MARINE RESTORATION & CONSTRUCTION LLC

Re: SHL22-006 and SEP22-005 – Response to Notice of Incomplete Application, 9843 SE 42nd Place

We received *Notice of Incomplete Application for File Nos. SHL22-006 and SEP22-005* dated April 4, 2022. We have addressed comment #2 in the section below and have attached supporting documentation. We will respond to comment #1 and #3 in a separate letter as soon as possible.

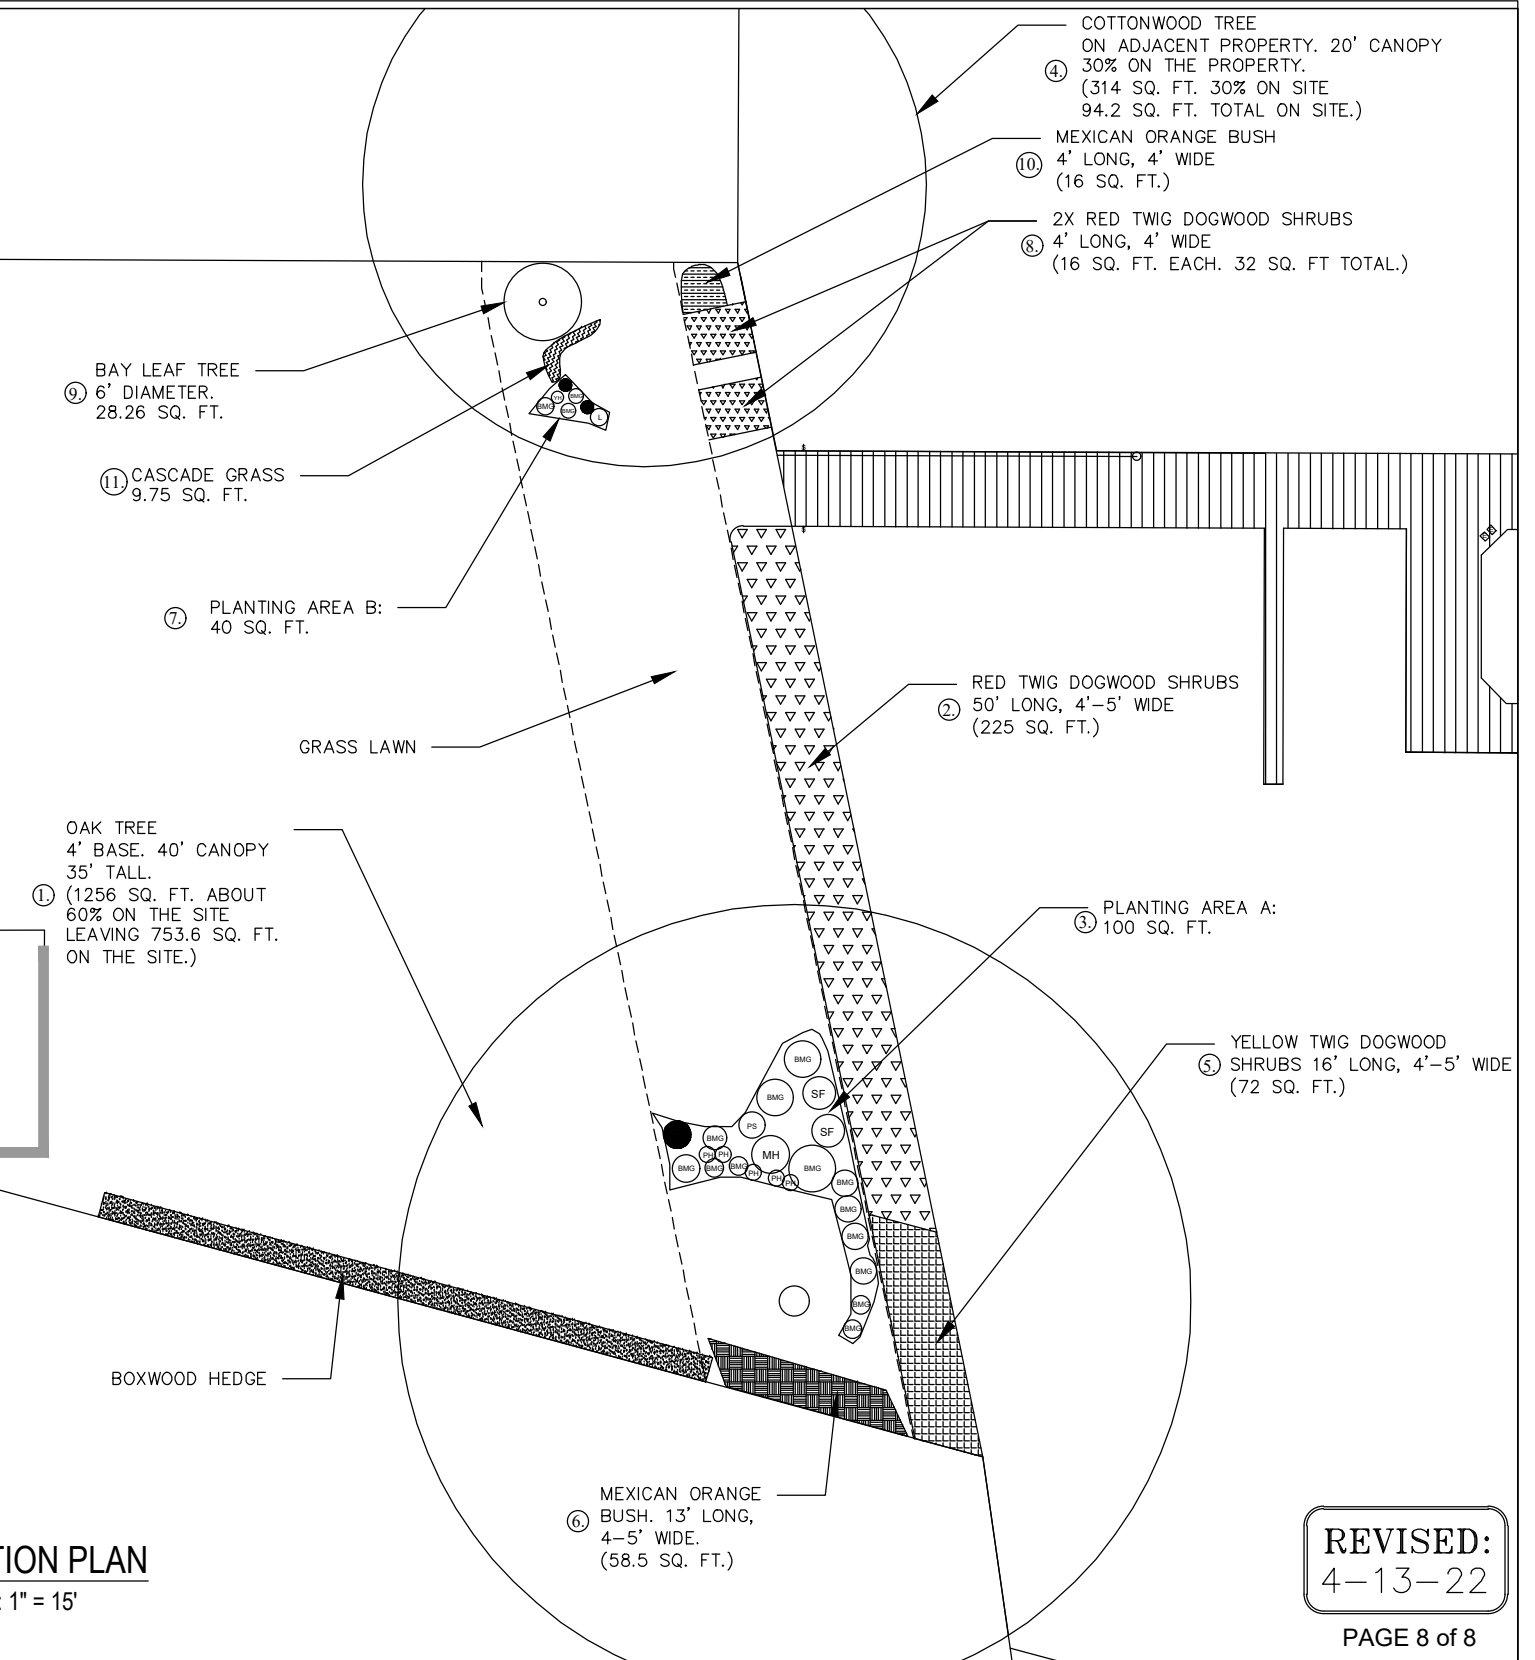
2. Provide a vegetation plan that conforms to MICC 19.13.050.F(1)(iii) and Figure C.

Please see attached, revised plan set dated April 13, 2022. The revised plan set includes a planting legend on page 8 which documents that the established native vegetation on site conforms to MICC 19.13.050.F(1)(iii) and Figure C.
